DELEGATED HOUSEHOLDER DECISION

Address: 40 CHENEY STREET EASTCOTE

Development: Erection of a single storey extension to the side and rear of the dwelling. Conversion of garage to habitable accommodation with amendments to fenestration. Conversion of roof space to habitable use to include 4 side facing roof lights, extension to the rear and conversion from hip to gable end with new gable end window to the rear.

LBH Ref Nos: 78059/APP/2023/2542

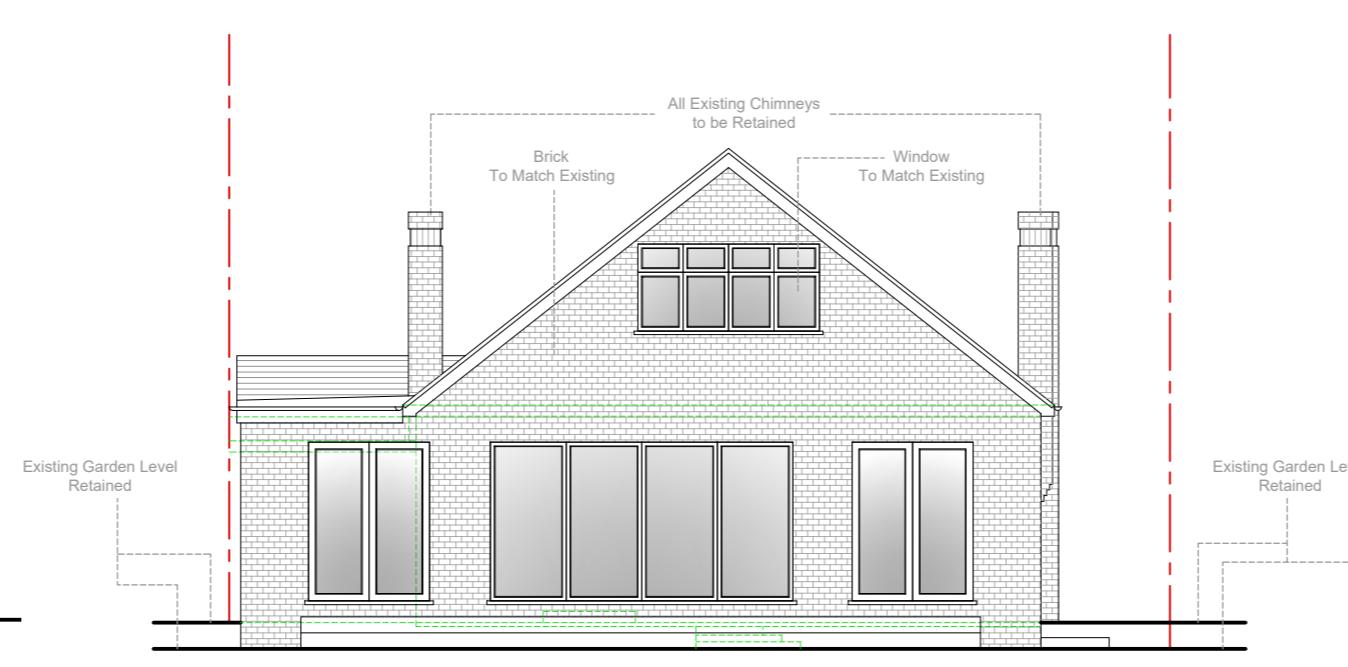
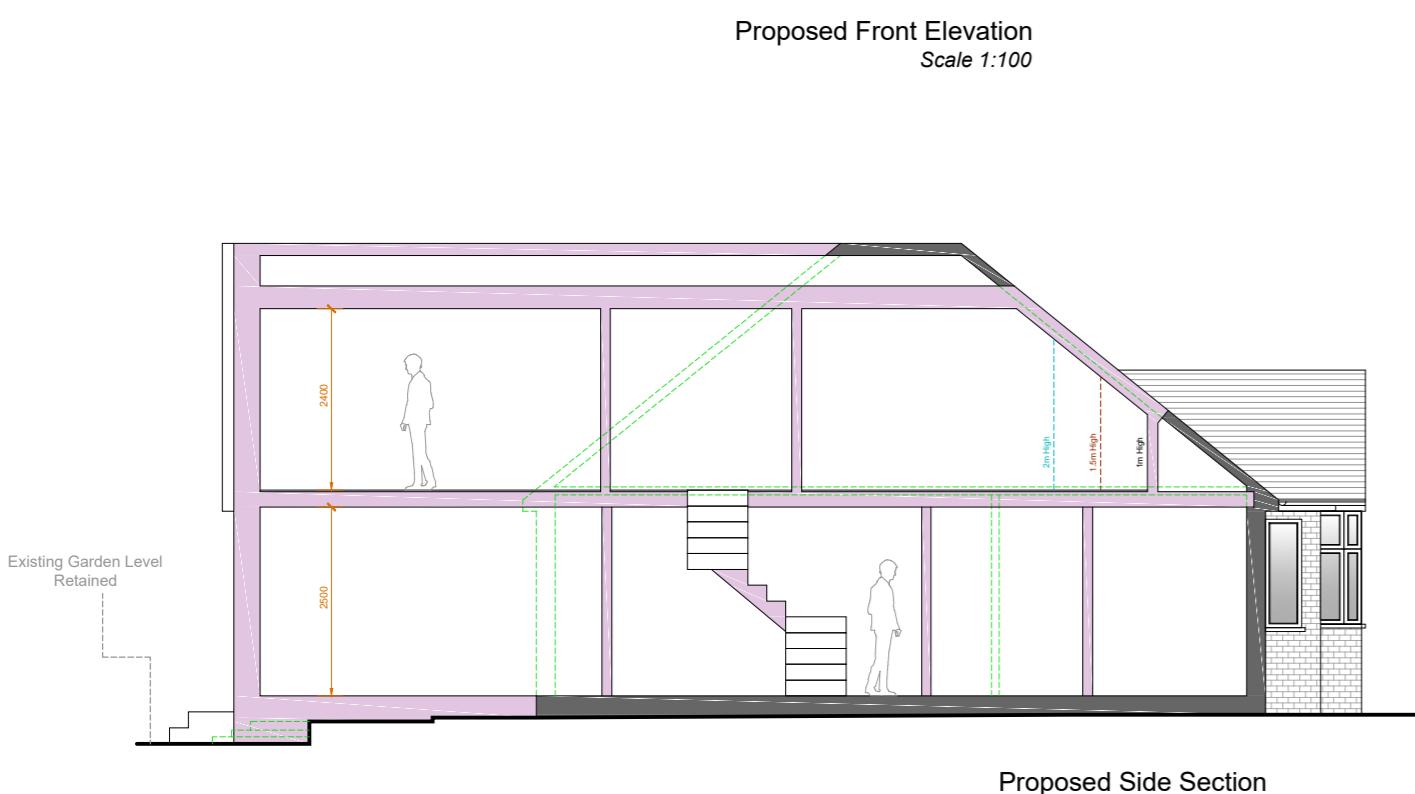
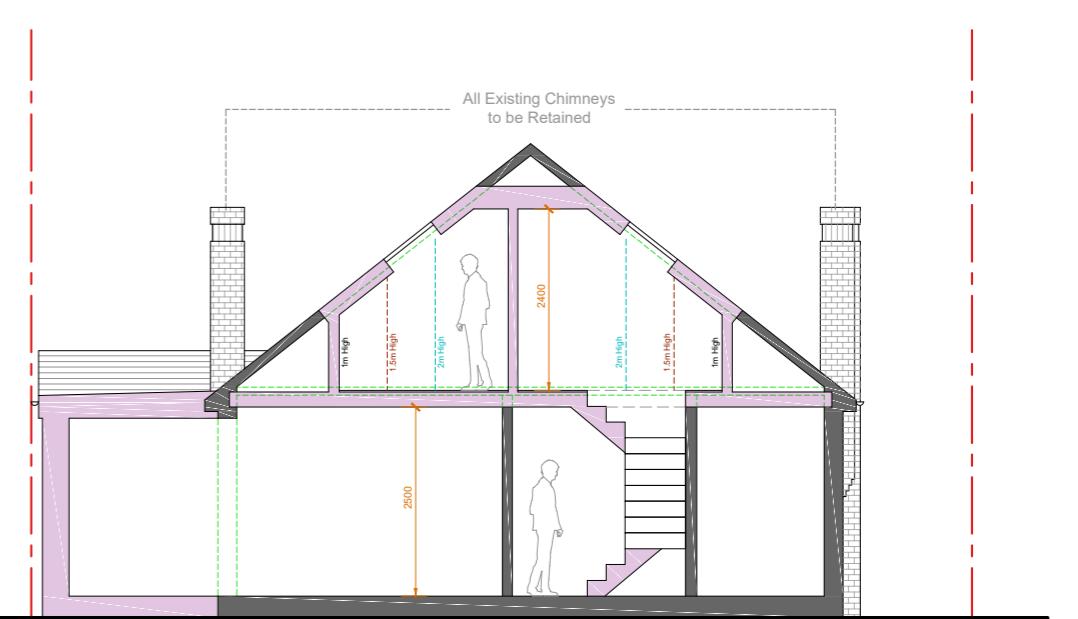
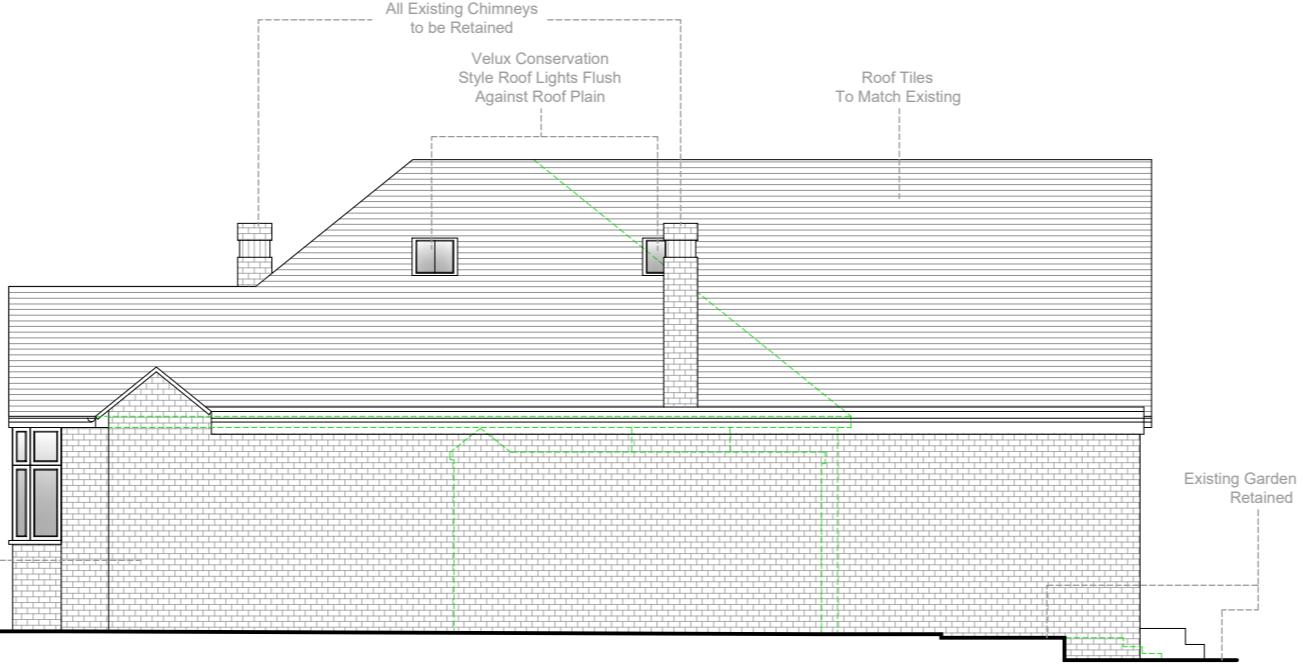
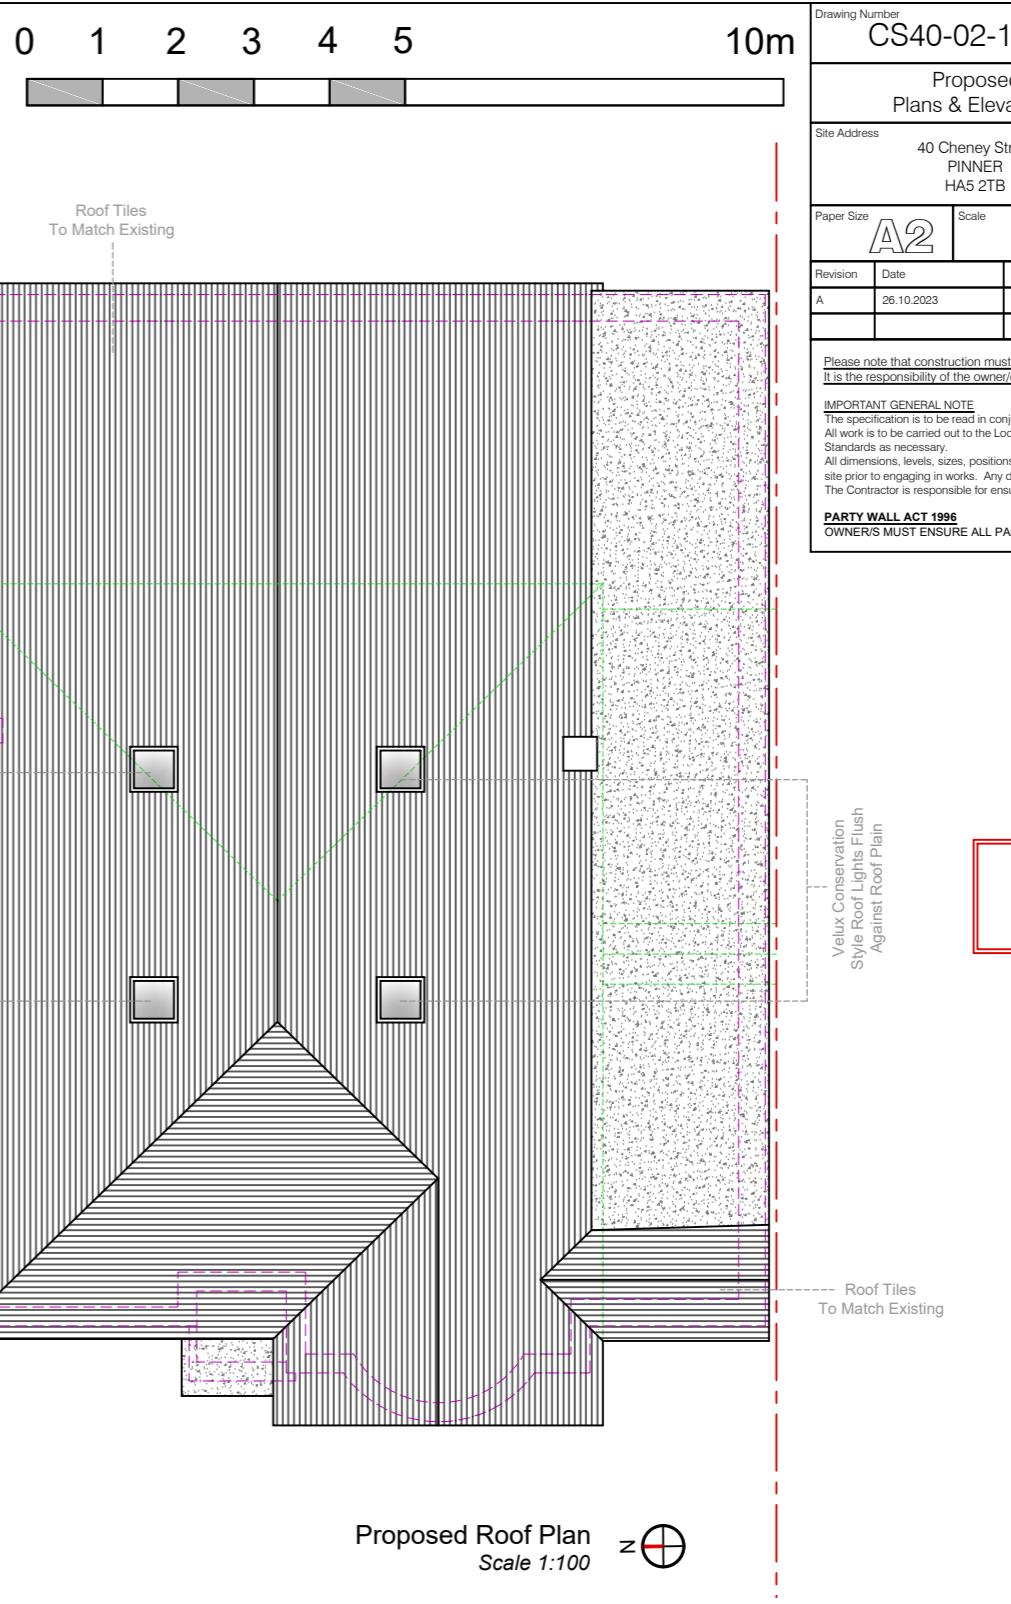
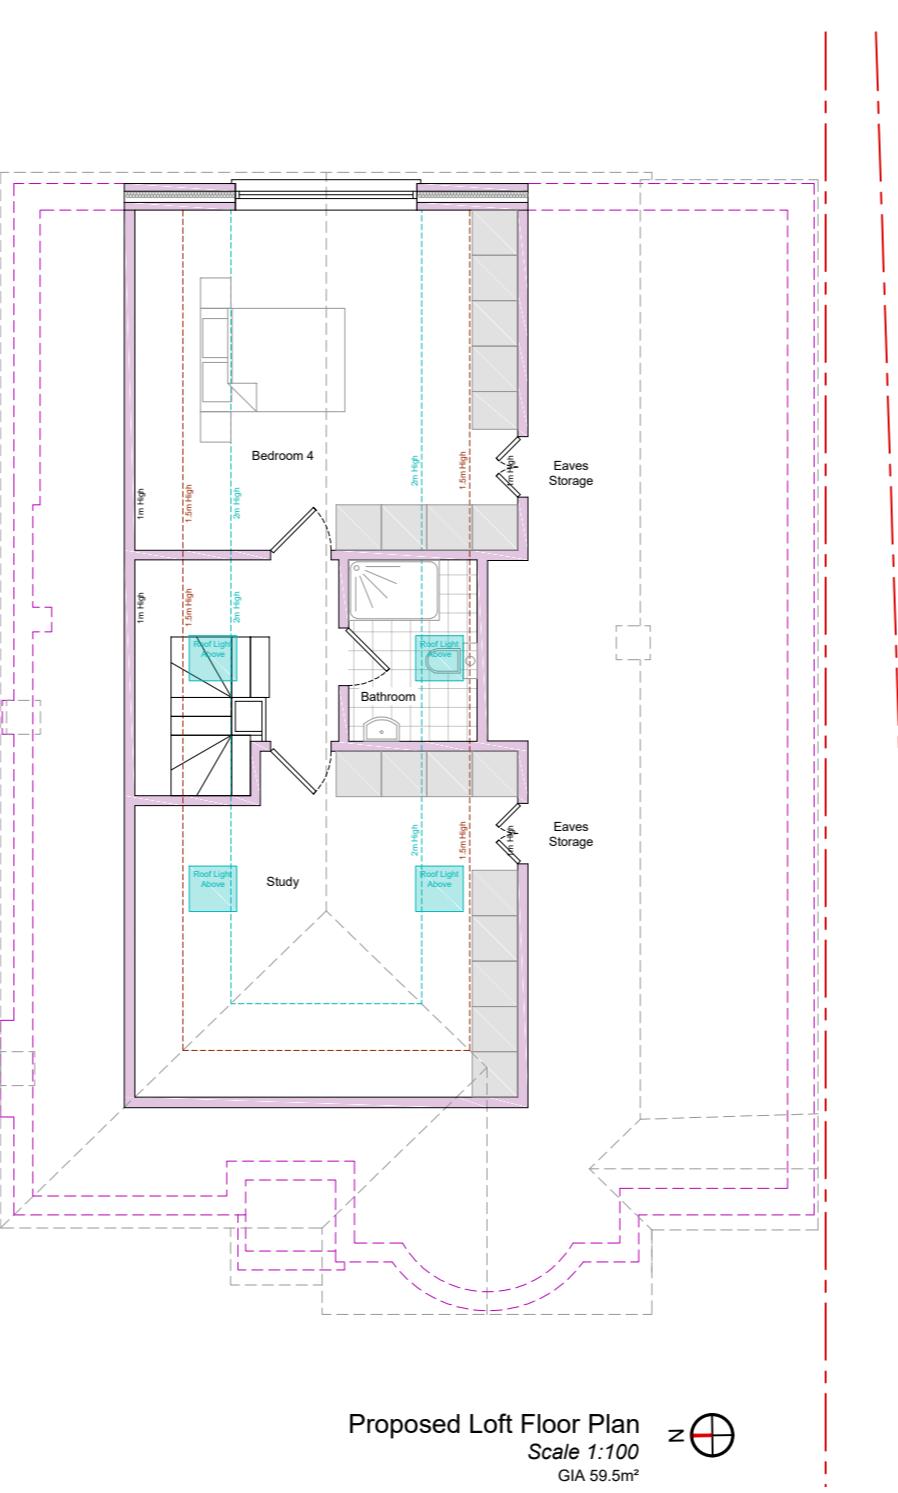
- The scheme in principle is acceptable
- Retain chimney

The plans have been revised to retain the chimney.

In addition, following revisions, the chimney is proposed to be retained.
